From: Tim Rainbird [REDACTED]
Sent: 01 August 2017 12:12
To: Paul Cann; Simon Davis
Cc: Tom Woolner
Subject: RE: BE/71/17/PL - Wickes, Bognor Drainage Scheme

Whilst I acknowledge the difficulties due to Network Rail's requirements, and the fact that the pumping station option may be commercially sustainable in this instance; it is not however environmentally sustainable in the long term. It's a shame the original gravity option to the Sainsbury's system was not implemented, and was clearly an oversight.

Having said that, we appreciate the predicament, and will in this case accept the principle of the pumping option. In order to progress matters in terms of formal approval, please could the following be provided;

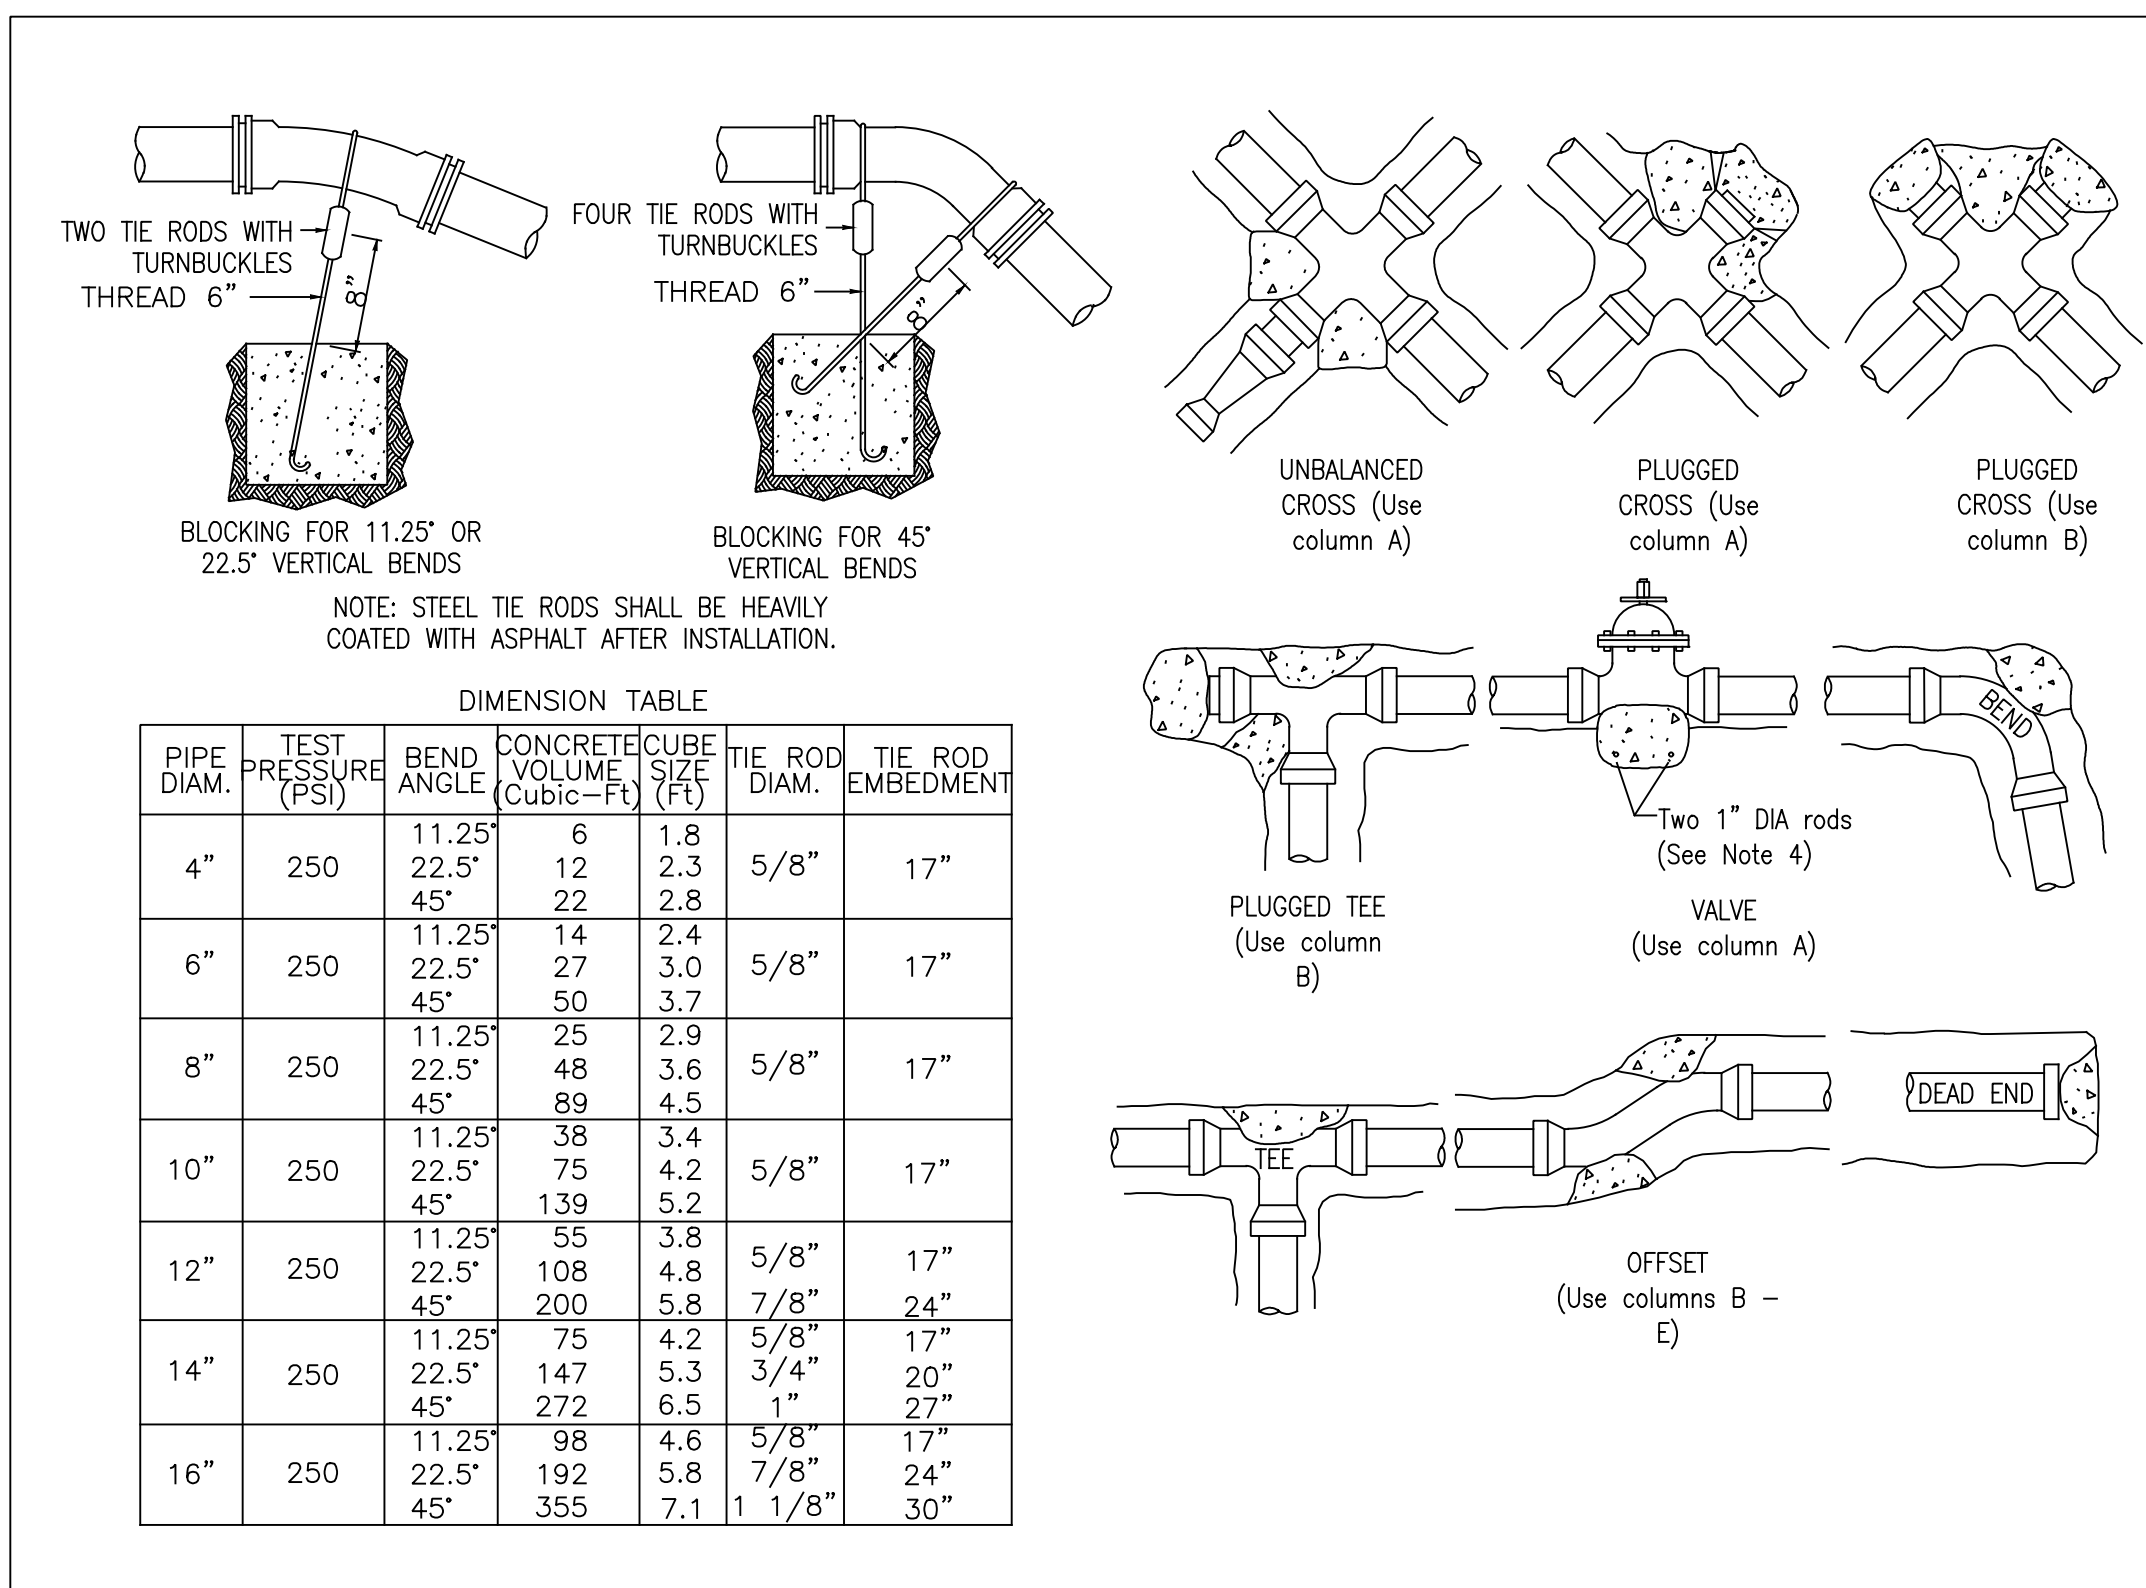
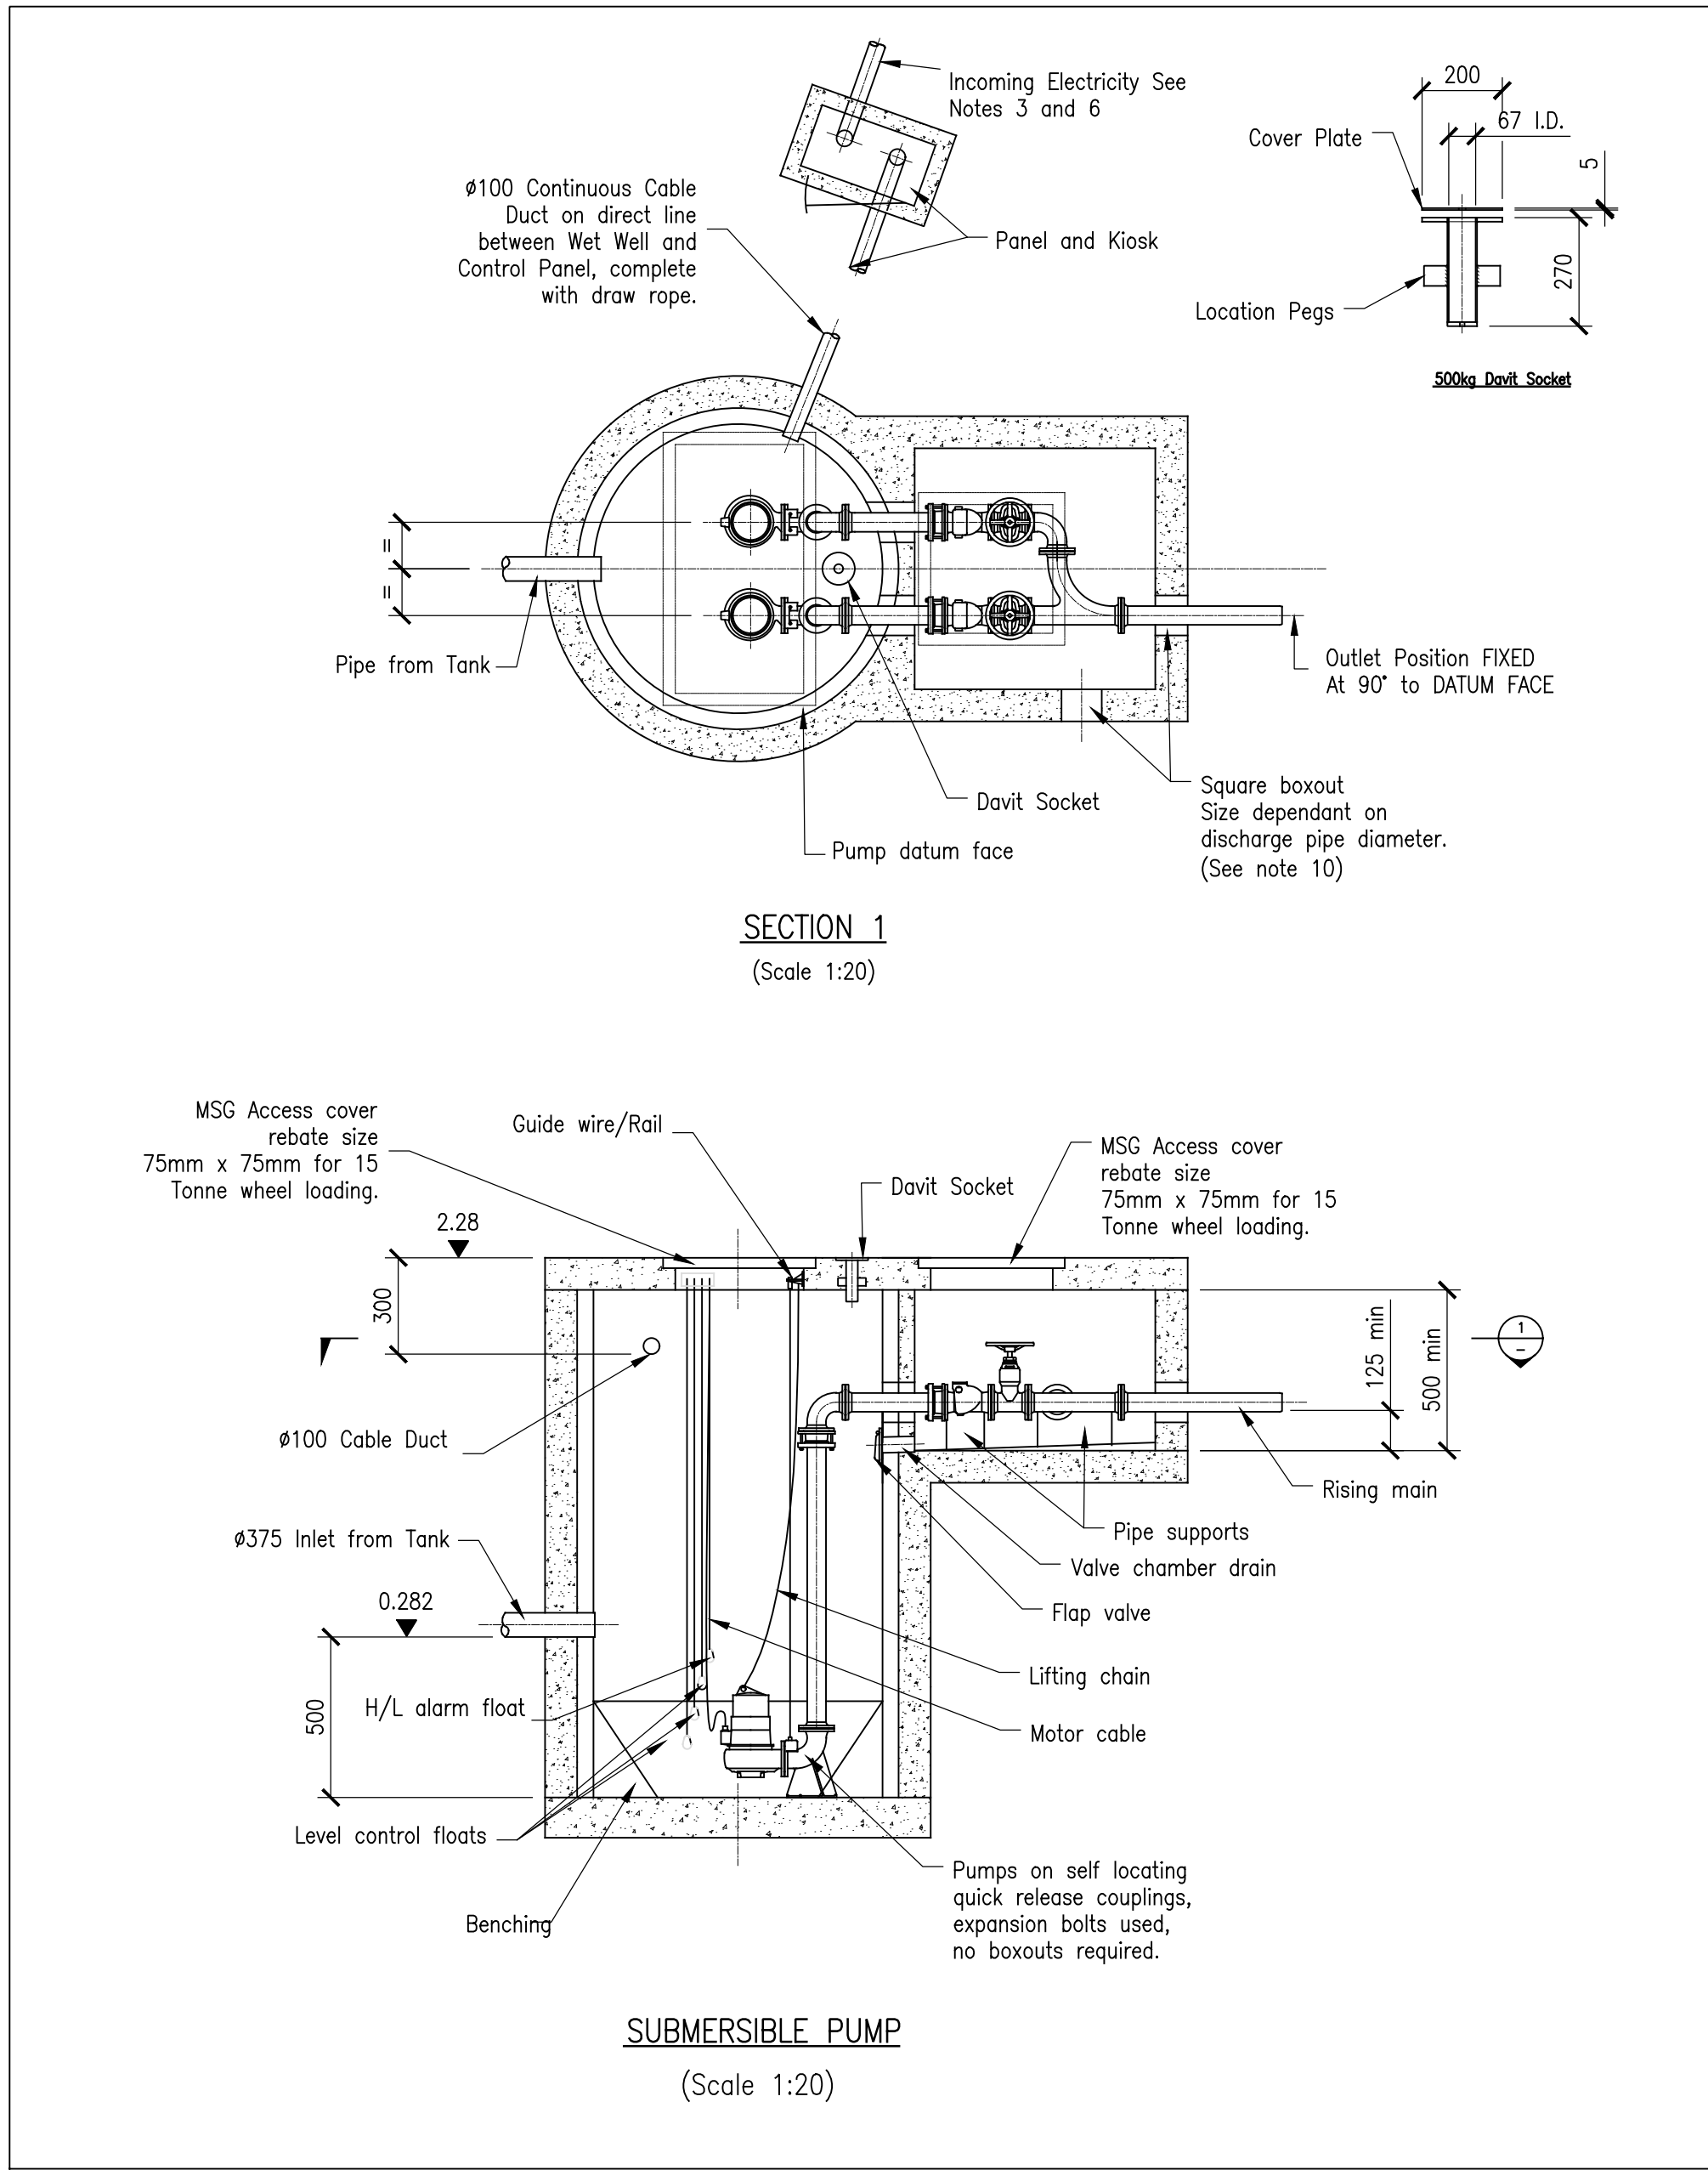
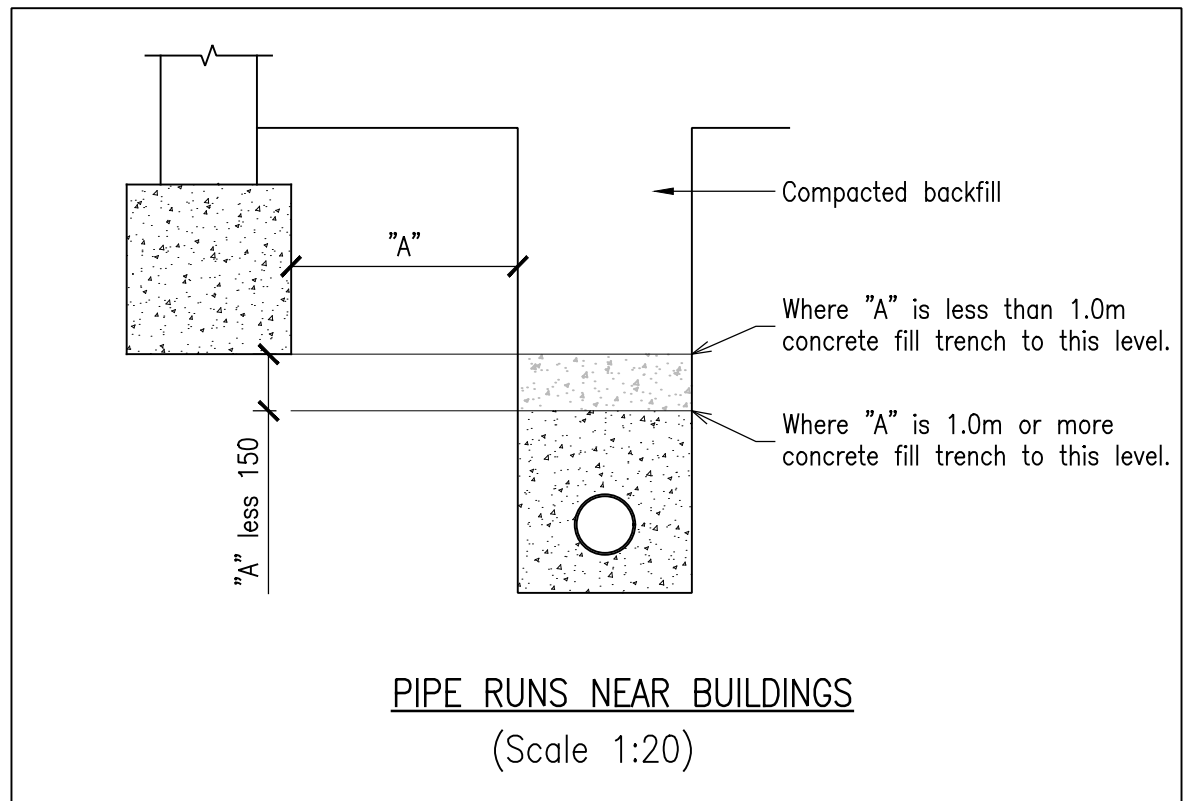
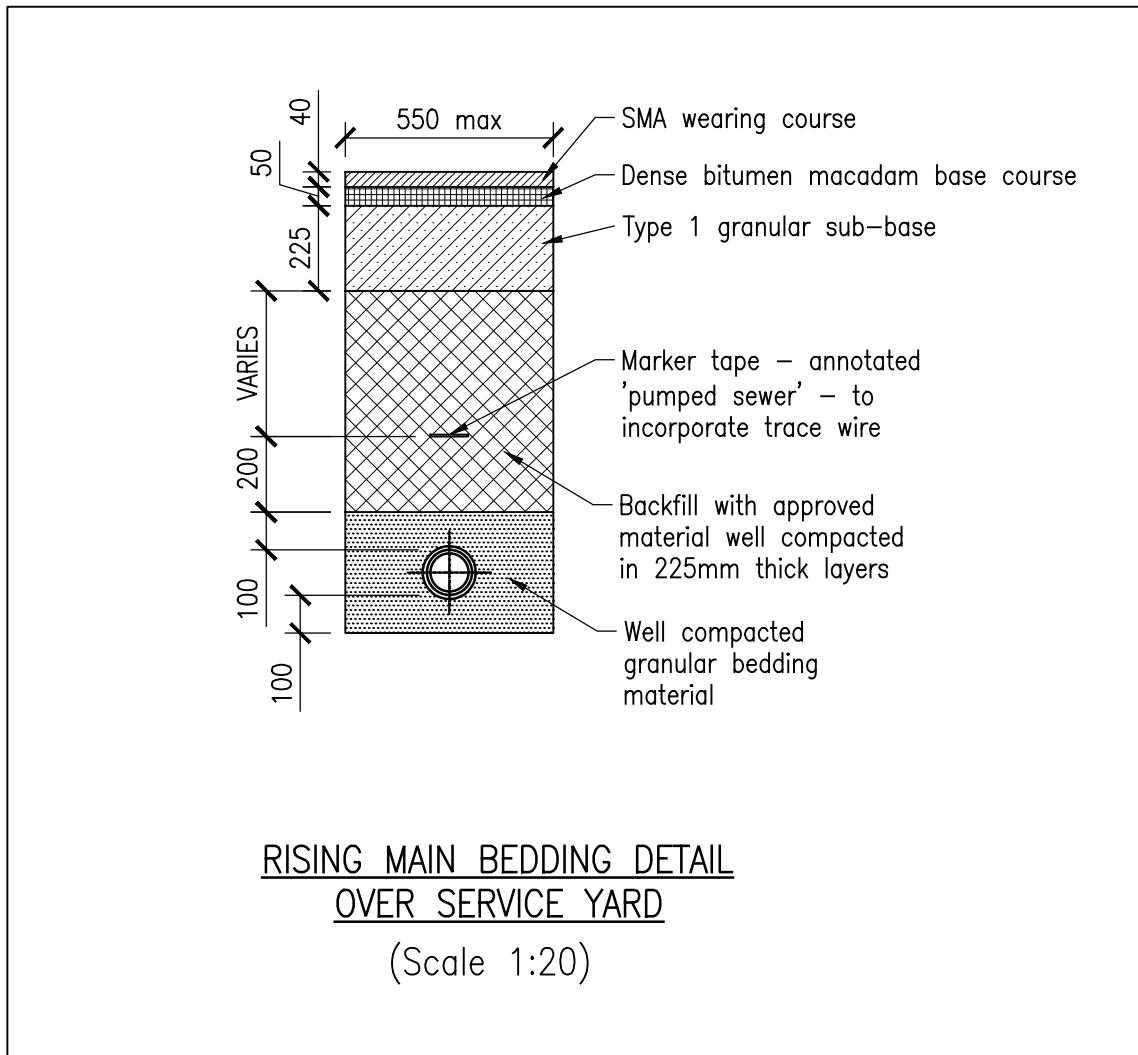
1. Full construction details of the pumping station and rising main. This will also need to include pipe bedding details, thrust block details and discharge chamber details.
2. Malfunction alarm details for the pumping station.
3. Pump manufacturers design/spec.
4. A maintenance plan for the future operation/maintenance of the pumping station.

It is important that the pipework configuration is considered carefully within the discharge chamber to ensure the smooth transition of flows. This will need to be detailed.

Typical details are on the attached drawing 15-112/500

The current discharge point is labelled as manhole S9 on the attached 'as built' drawing from the adjacent Sainsburys development. Specific details of this chamber is unknown although those of upstream chambers S10.1 and S10 are. Hence levels will be confirmed to the pump supplier when the contractor orders the pump.
